Please ask for: Nicola Moore
Email: nicola.moore@arun.gov.uk
Telephone: Ext 37944
Our Ref: F/12/21/CLP
Your Ref:
Date: 23rd June 2021

Lawful Development Certificate for a Proposed Use or Development

Development: Lawful development certificate for a proposed single storey flat roof rear extension.
Location: 14 Abbots Field Yapton BN18 0GE

AS EXISTING

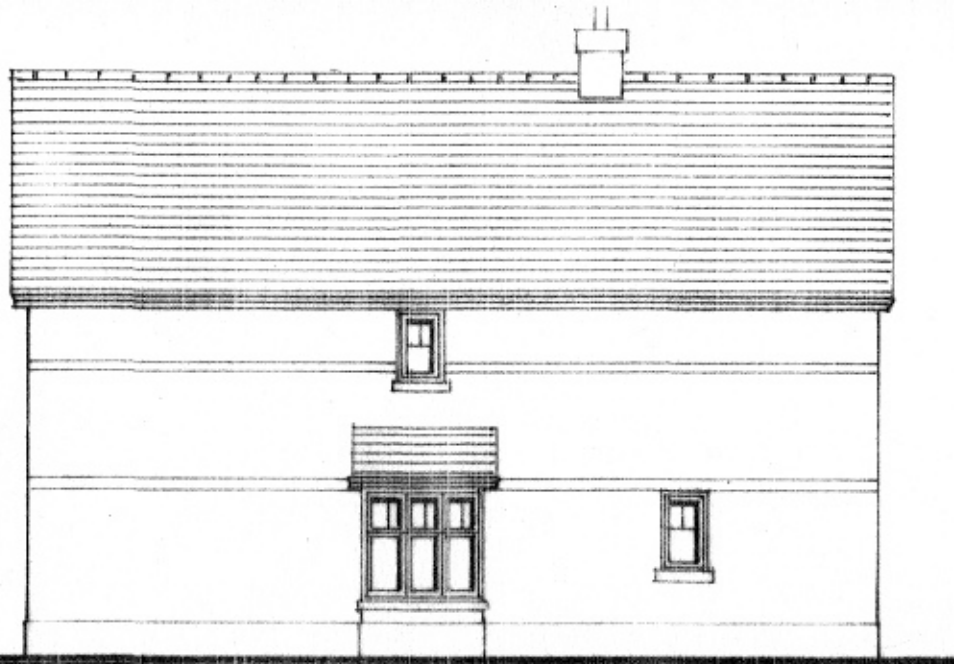
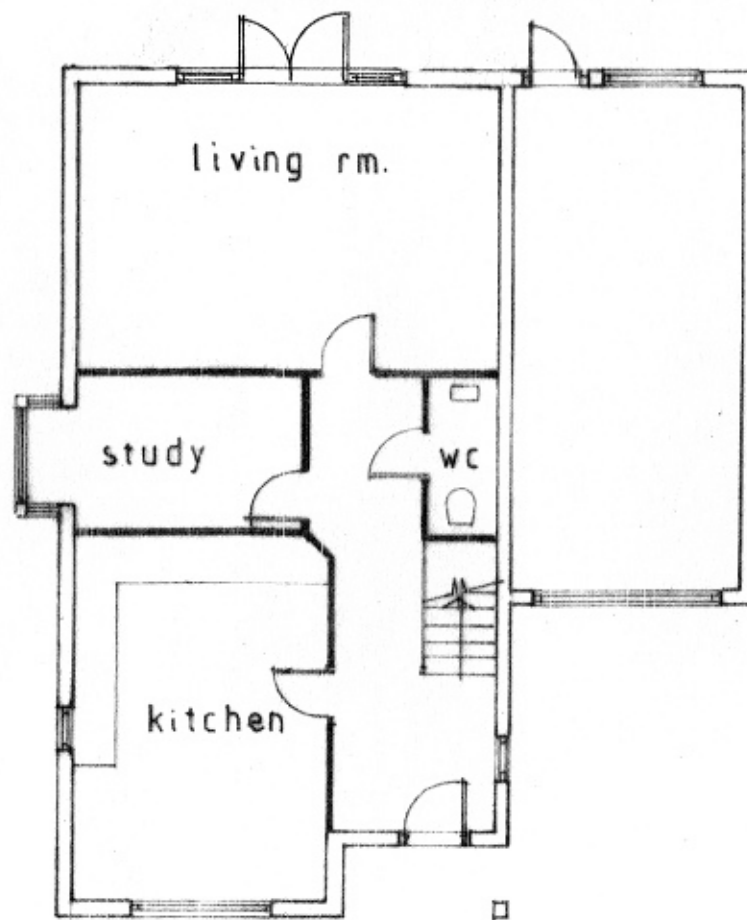
Please submit clearly labelled existing floor plans and elevations.

Please clearly label the submitted floor plans and elevations existing or proposed and re submit.
